**Transport  
for NSW**

**Forensic Pathology and Coroner's Court, Lidcombe (SSD 7545)  
Notice of Exhibition**

## **TAB A – Request for Further Information/Clarification**

Figure 4 – Public Transport Services - Buses

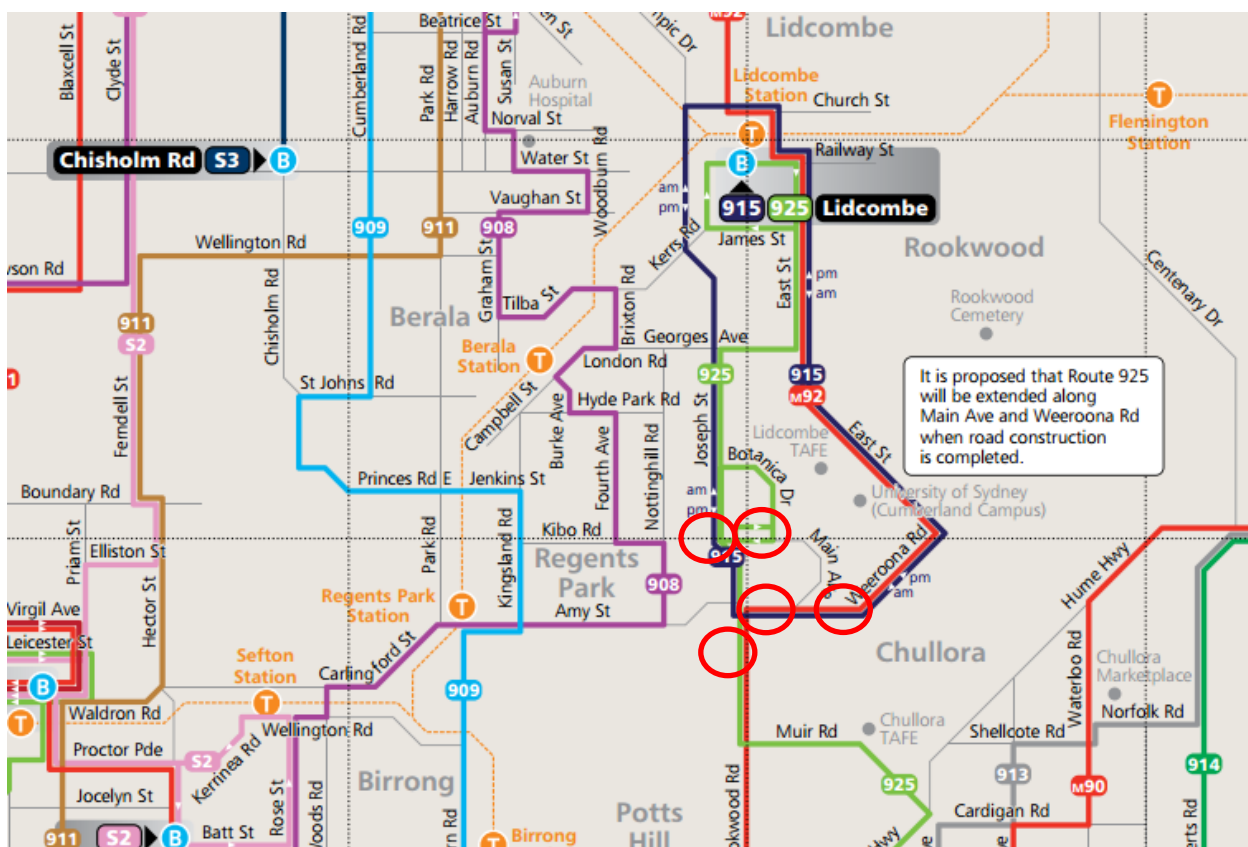
Section 8 of the TPA report provides a discussion on sustainable transport options which provides objectives and measures to encourage public and active transport for staff and the public. It is noted that TPA states that the only public transport to the site is route 908. However, it should be emphasised that the site is serviced by Metro Bus route M92, which operates high frequency services from Parramatta Interchange to Sutherland via Lidcombe Railway Station.

Health Administration Corporation be conditioned to prepare a Travel Access Guide and Workplace Travel Plan that would:

- Identify travel demand measures that could be implemented to encourage active and public transport trips for staff and public including measures identified in Section 8.2 of the TPA report.
- Include provisions to monitor and report on the effectiveness of the proposed measures and mechanisms to implement further improvements.

Figure 9 – Site Access Road

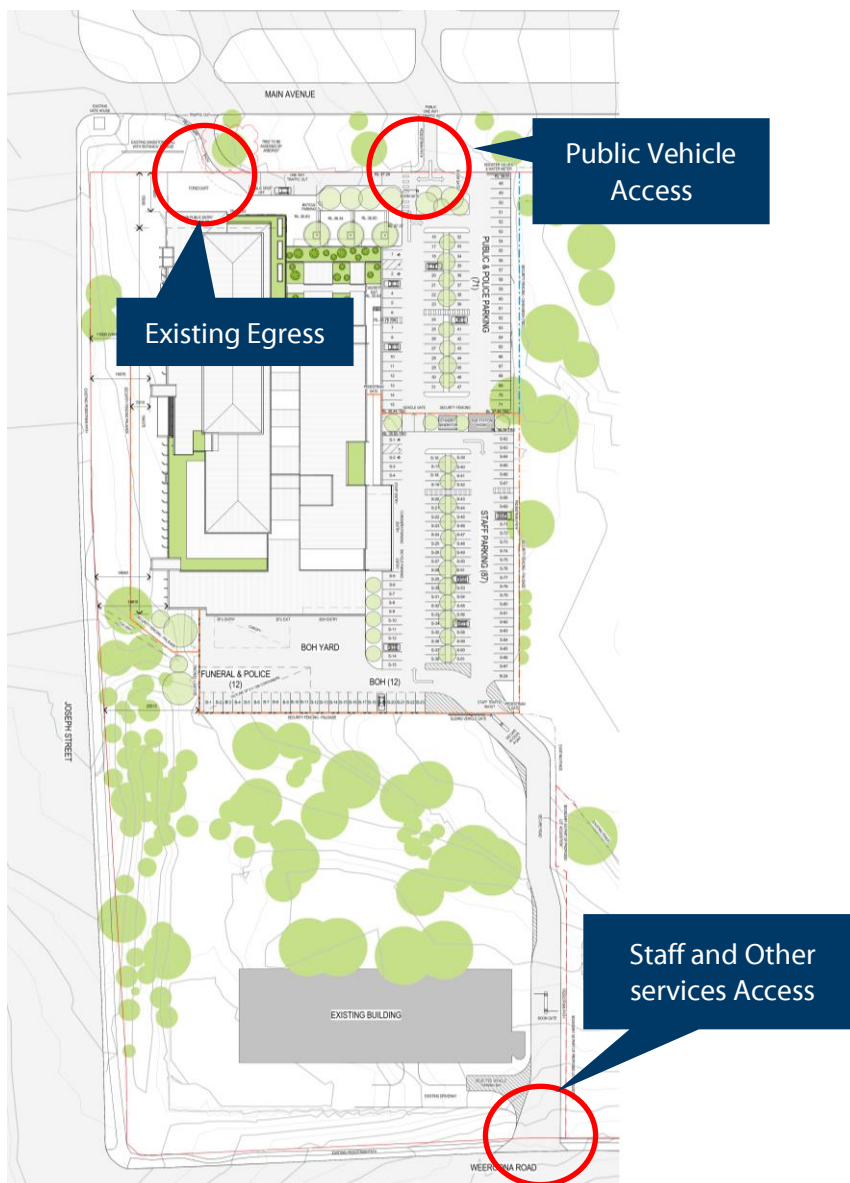
The access driveway for the staff carpark is proposed on Weeroona Road approximately 30m east of the existing 'Bus Zone'. The proposal also includes two boom gates (in series) are on the proposed driveway. Concerns are raised that vehicles turning in and out of the site might impact on the operation of M92 bus route. Queueing and intersection analysis of the access is required to determine any delay impacts on the M92 bus route and identify suitable mitigating measures if required.

Health Administration Corporation should be requested to provide queueing assessment and intersection analysis (including SIDRA modelling) for the proposed staff access driveway on Weeroona Road to assess the impact on through traffic including the M92 bus route. The queueing analysis should consider the proposed boom gates based on justified service and arrival rates. It should be demonstrated that during peak periods (i.e. 30 minutes before shift start in the morning), staff vehicles queueing to enter the site would not extend to Weeroona Road and impede on the M92 bus route. The analysis should also consider the comments provided below in relation to traffic generation and distribution assessment particularly in relation to development traffic from the Weeroona Road east turning right turn into the site.

Details of any recommended traffic management measures required to minimise delay on the M92 bus route should be provided. The measures should be designed to accommodate bus movements in accordance with Austroads and Australian Standards to the satisfaction of Council.

Figure 10 – Construction Vehicle Route Plan

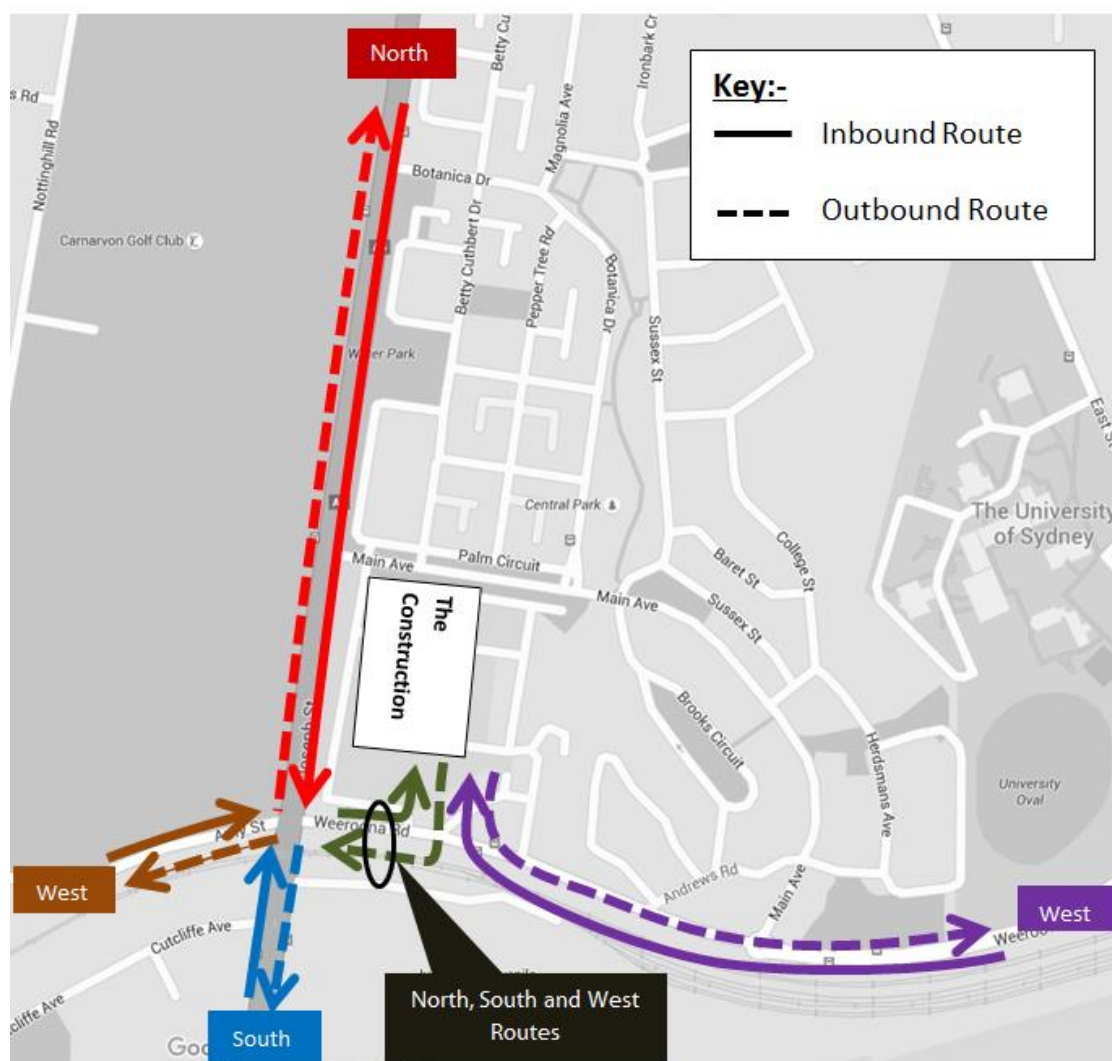
Figure 10 of the TPA report indicates all construction vehicles would use Weeroona Road. This has the potential to have major impacts on the operation of bus services including M92 bus route which needs to be carefully considered.

Health Administration Corporation should be conditioned to prepare Construction Traffic Management Plan (CTMP). The CTMP should be prepared by a suitably qualified person a prior to the commencement of any works on the site. It should be submitted to the Principal Certifying Authority (PCA). The Plan must be prepared in consultation with Council, Roads and Maritime Services and TfNSW. The CTMP should specify any potential impacts to traffic, pedestrian, cyclists and bus services (ie bus routes M92 which travels along Weeroona Road) within the vicinity of the proposed site from construction vehicles during construction. Any potential impacts to pedestrian access or public transport infrastructure including bus stops should also be specified in the CTMP.

The CTMP should include the cumulative construction impacts of all the projects adjacent to the site. The applicant should submit a copy of the CTMP to Council, prior to the commencement of work.

2026 Traffic Intersection Volumes (Existing + Development) PM Peak

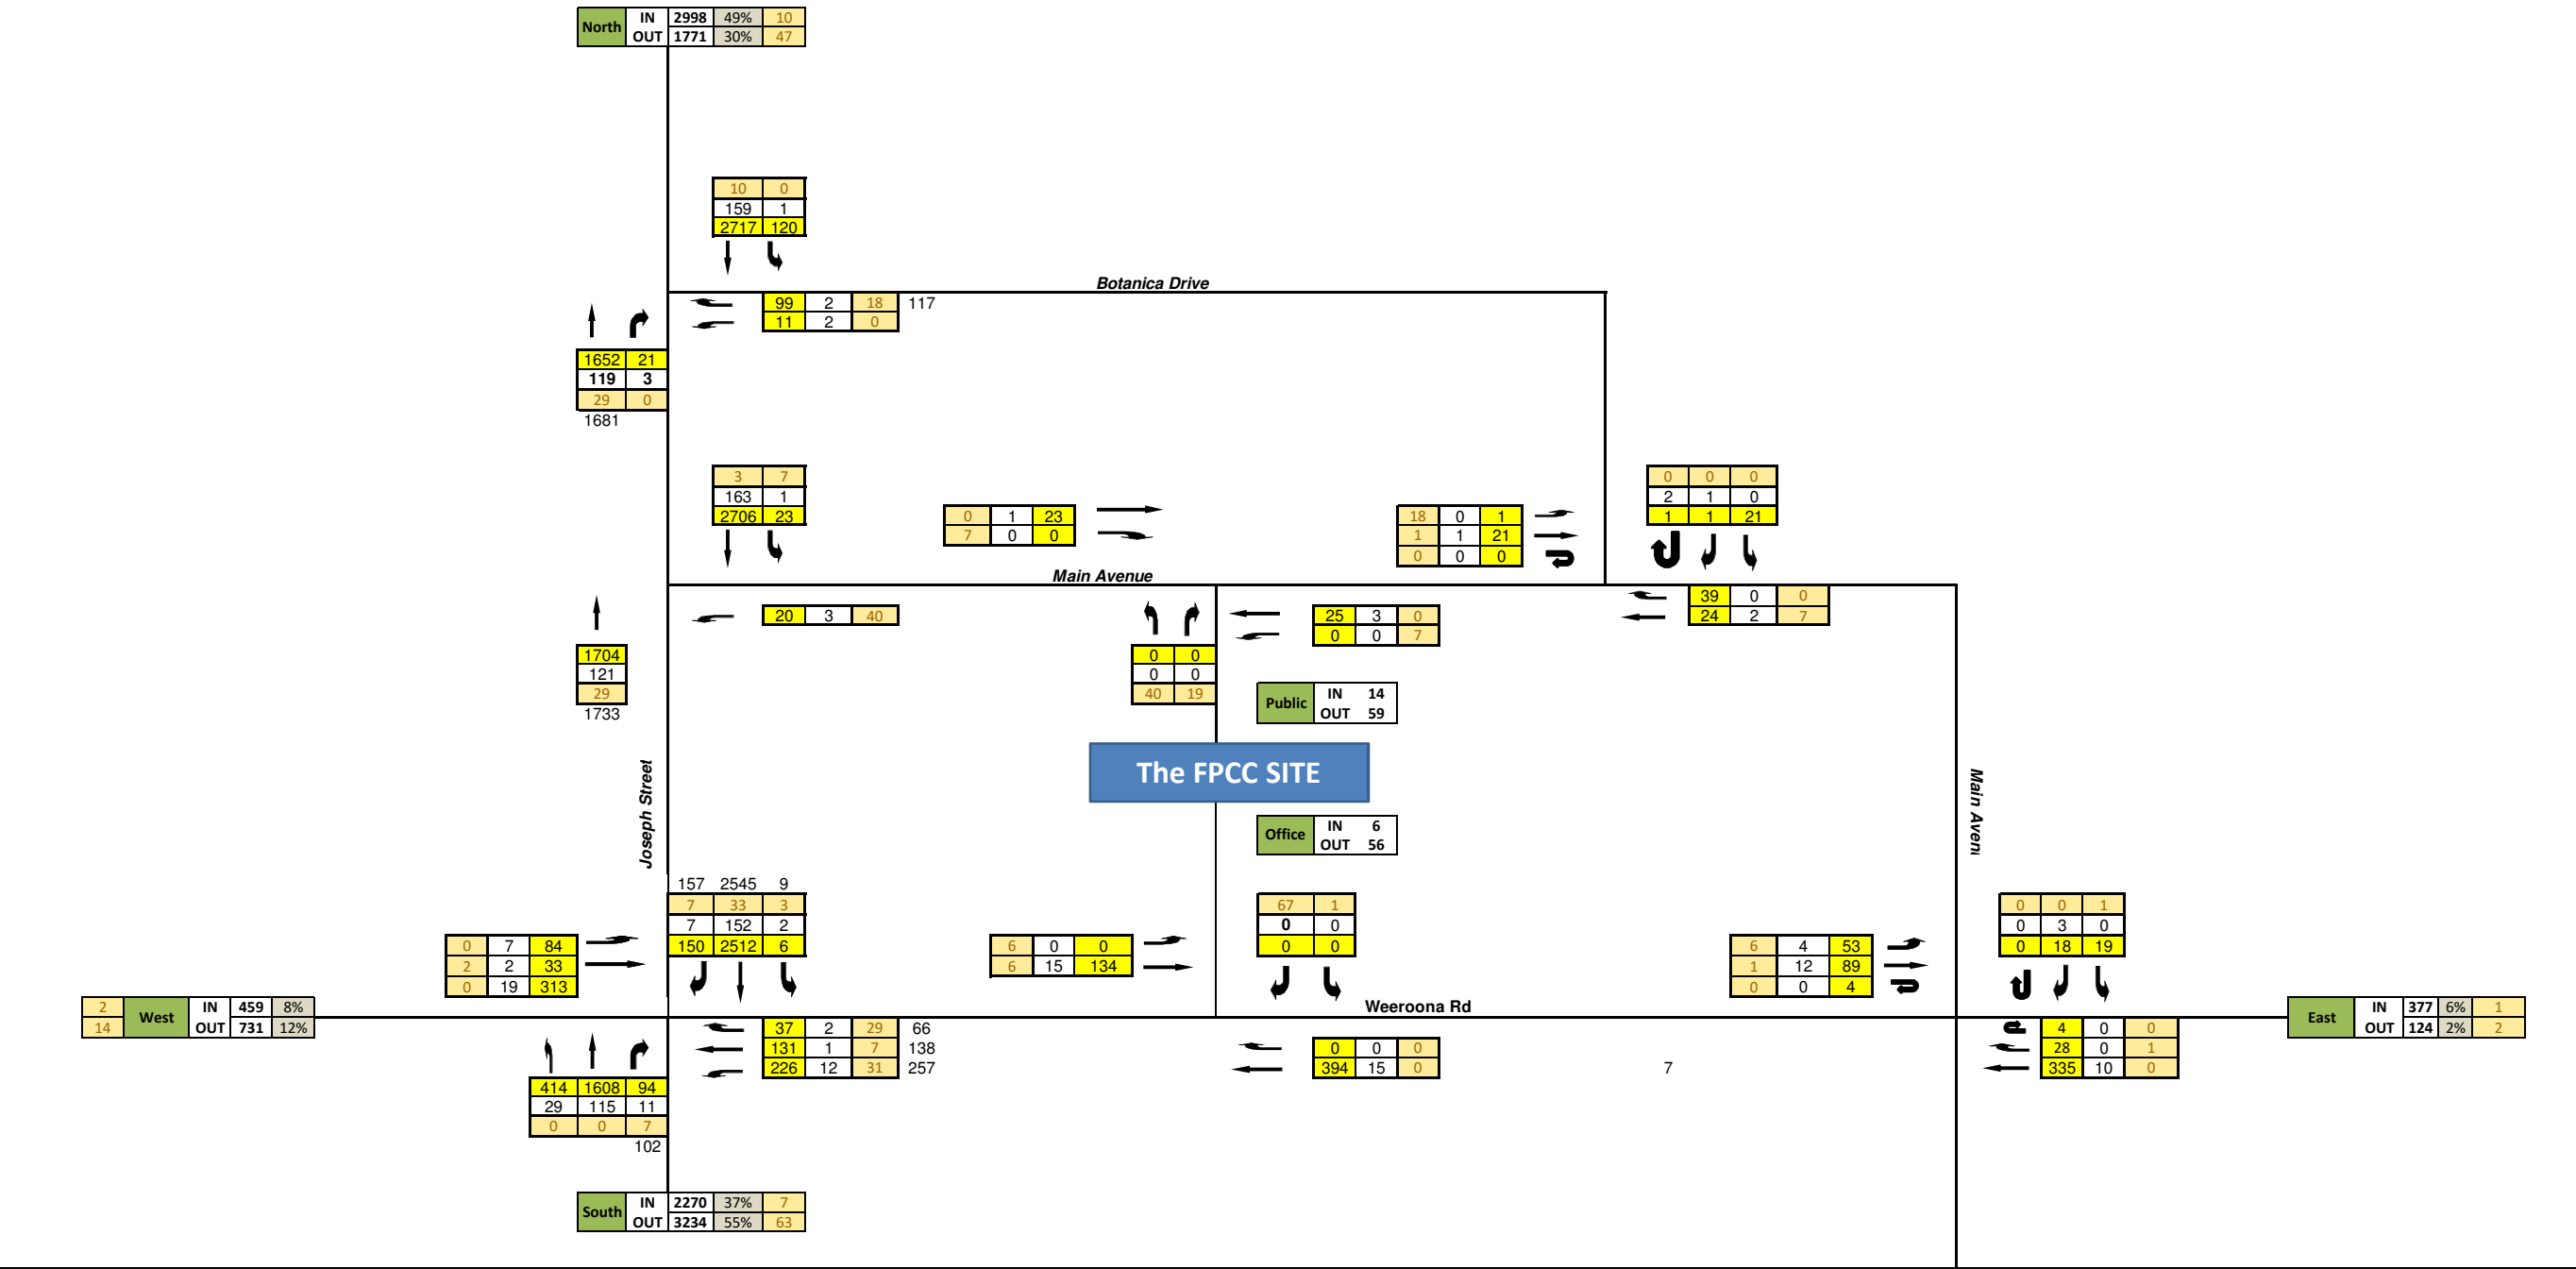
- Directional distribution table (Table 7) should correlate with Development Traffic Intersection Volumes figures (Attachment 3). As an example, Table 7 shows East Inbound PM development traffic is 37%, however the 2026 Traffic Intersection Volumes (Existing + Development) PM Peak figure shows no vehicles turning right from Weeroona Road east into the site.

Further assessment and clarification should be undertaken on the traffic generation and distribution assessment with consideration of the above.

The intersection analyses should consider any updates resulting from the traffic generation and distribution review which should also be considered in the intersection analysis of the proposed access driveway on Weeroona Road detailed above.
